Application Ref:24/00115/LBC

<p>UPRN: 000120029460 (If NO UPRN – Admin to contact Technician)</p> <p>Site Address: <i>(Leave blank if no UPRN)</i> 57 Main Street Pathhead</p>	<p>Description of Proposal: Repointing of stonework and installation of vent pipe</p>
--	--

# Measurements of external extractor unit

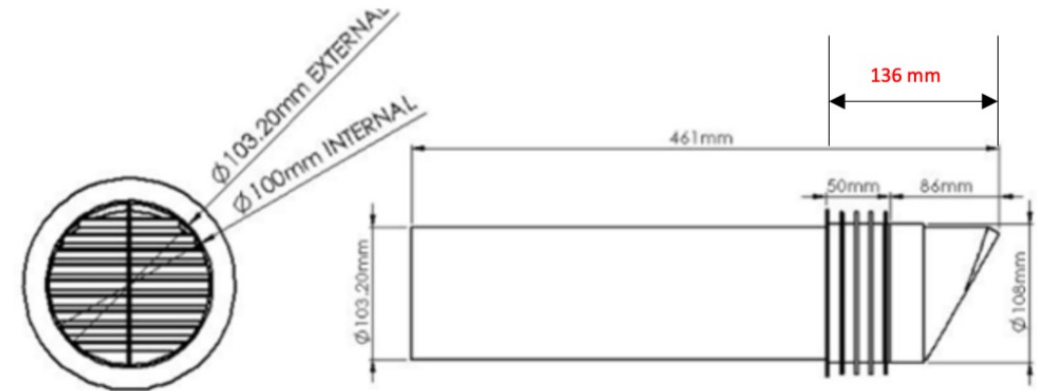
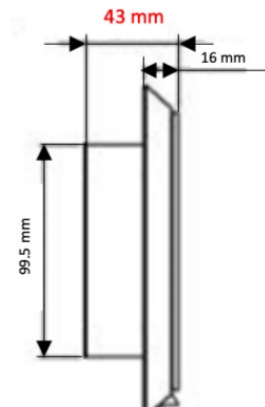
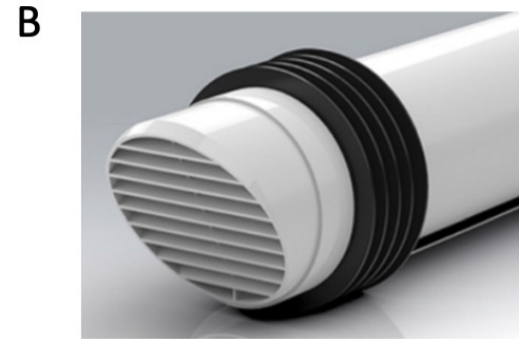
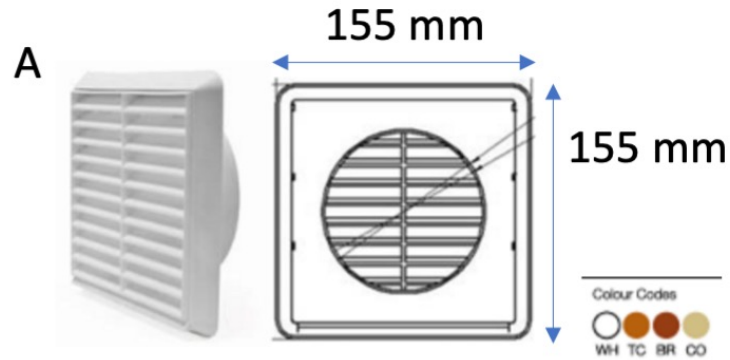
| <input checked="" type="checkbox"/> | Inadequate Plans | The following additional plans are required: <ul style="list-style-type: none">- Please provide details of design, colour and dimensions of the external vent pipe including how far it will project from the rear elevation of the house and its diameter. An annotated photograph, brochure detail or drawing would be acceptable. |
